Sheringham Shoal Extension and Dudgeon Extension Offshore Wind Farms

**Appendix E1 to the Natural England Deadline 2 Submission**

**Natural England's Advice on [REP1-059] 13.5 Marine Processes Technical Note**

7<sup>th</sup> March 2023

Figure 6.11 Zone of Potential Influence on the Tidal Regime

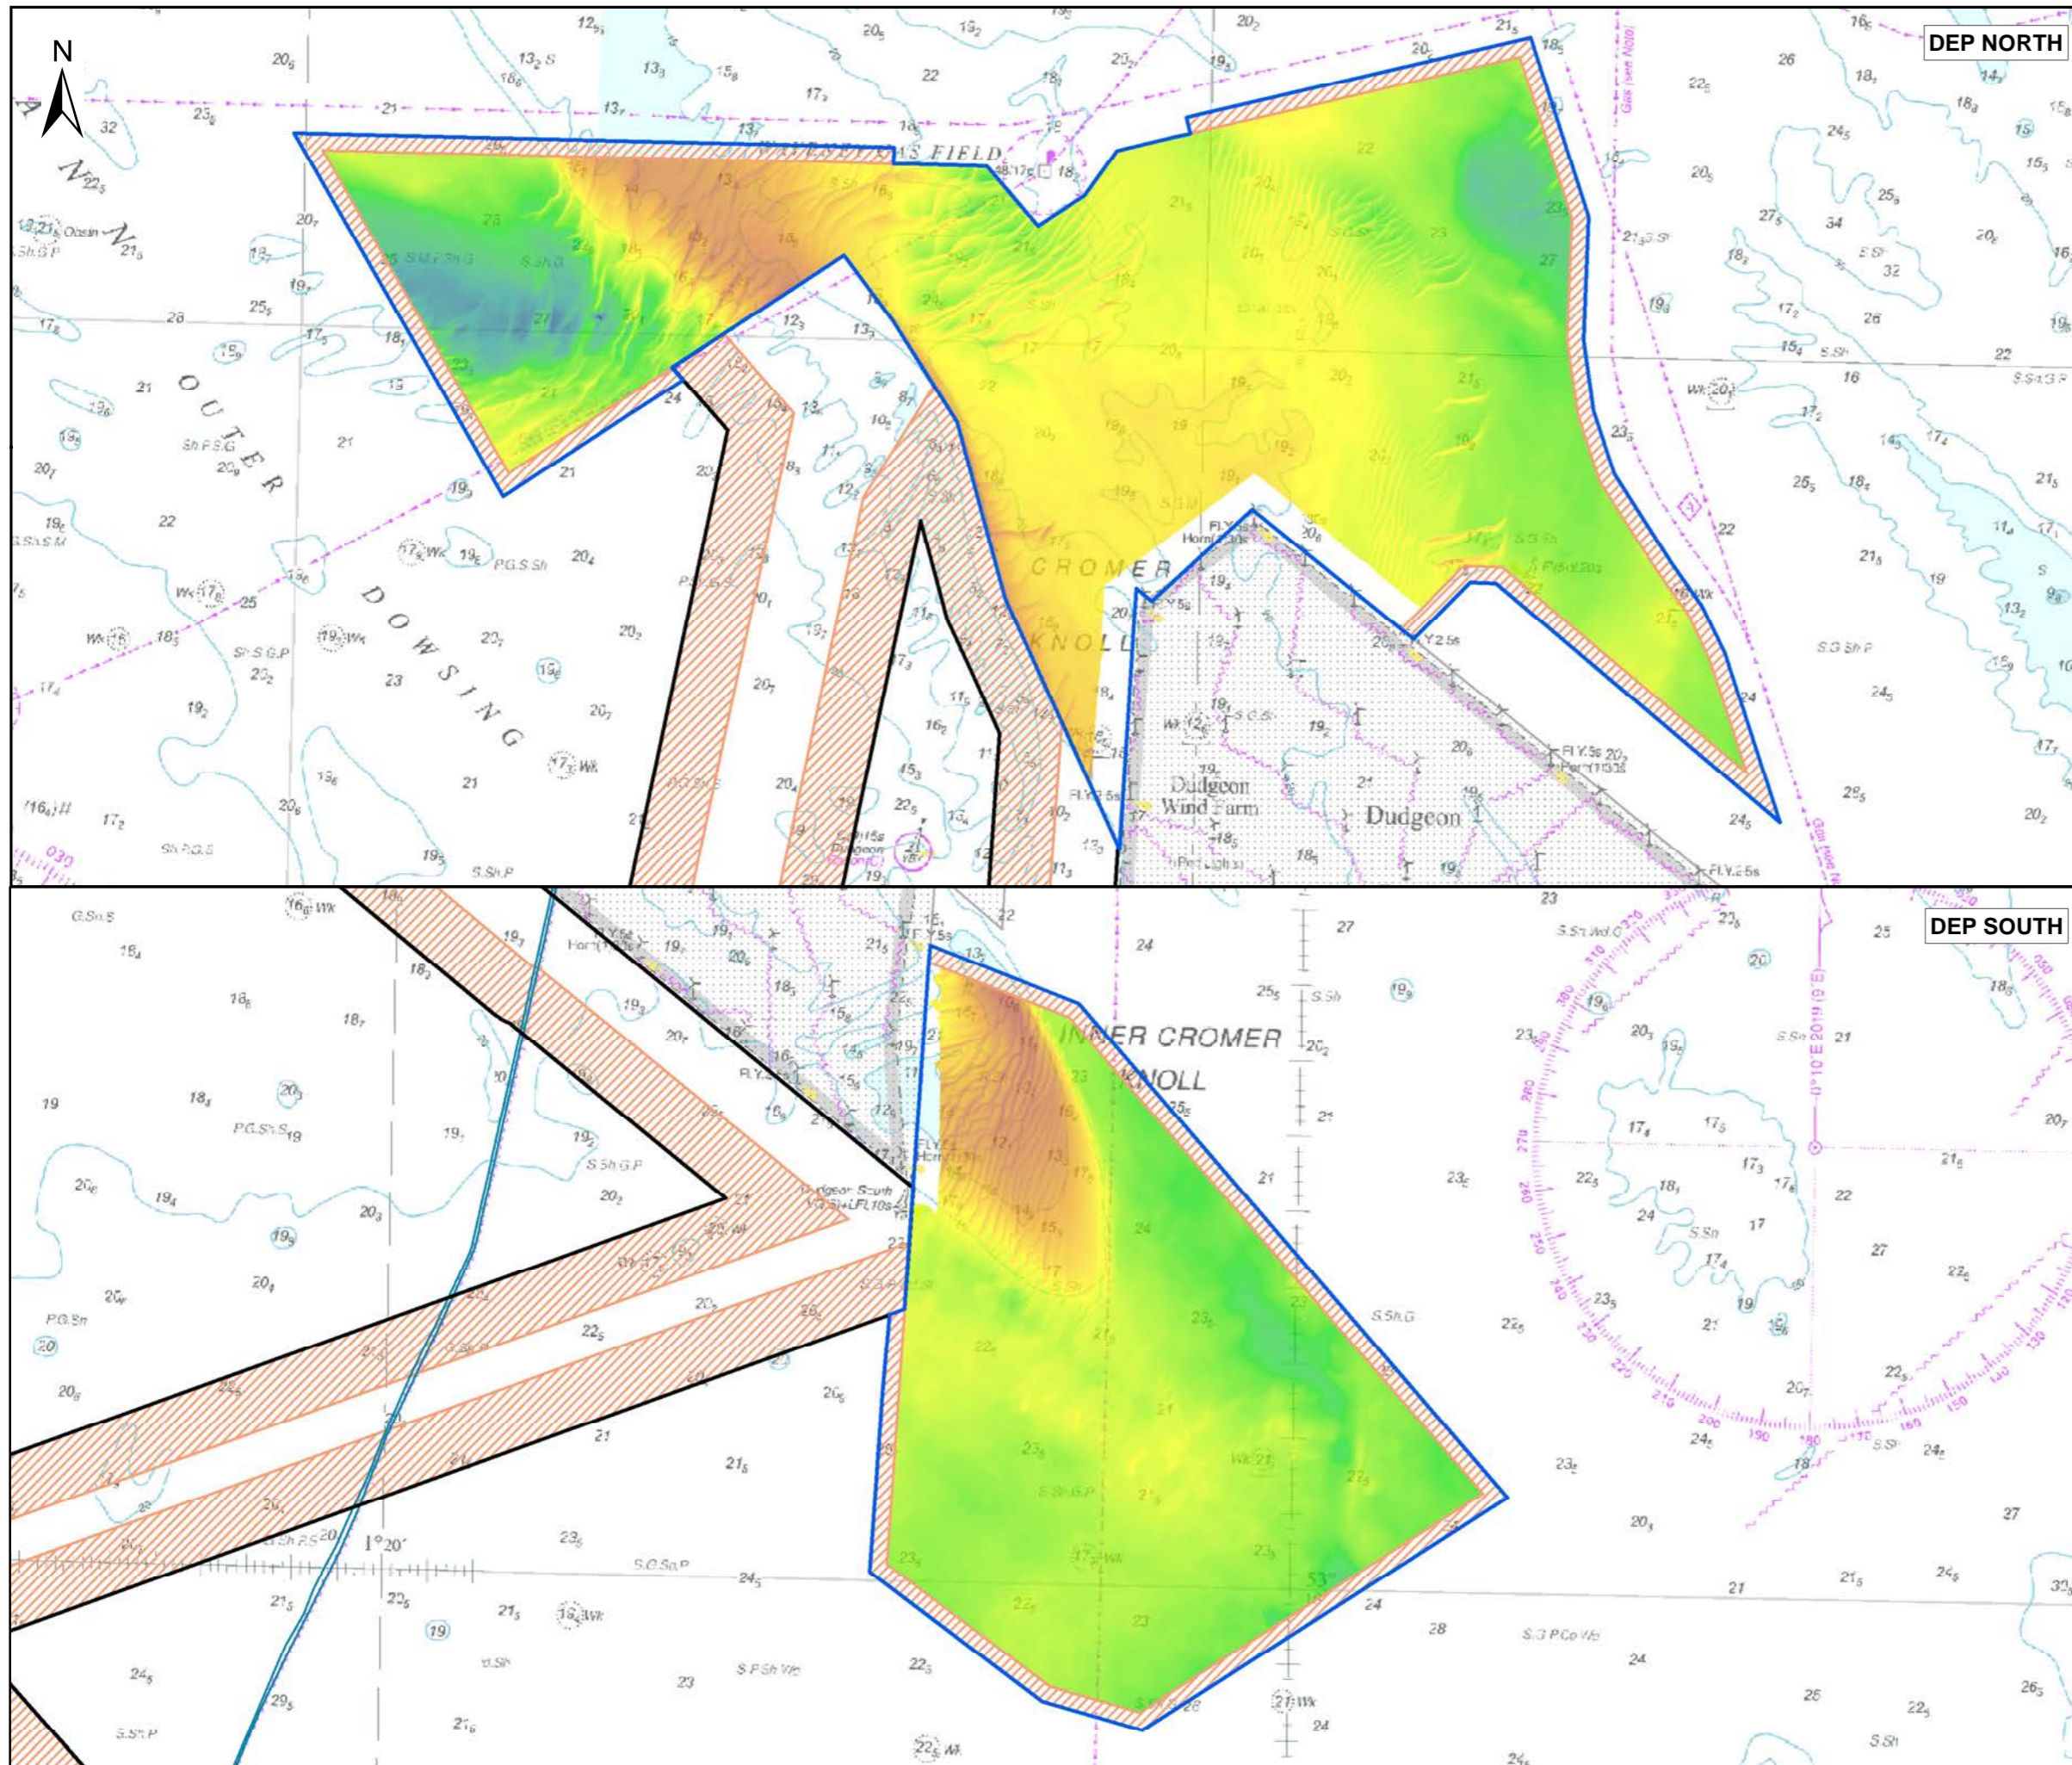
We welcome the updated Figure 6.11 (Figure 10) provided by the Applicant showing the Zone of Potential Influence on the tidal regime in the context of Marine Protected Areas (MPAs). Natural England's concerns have now been addressed.
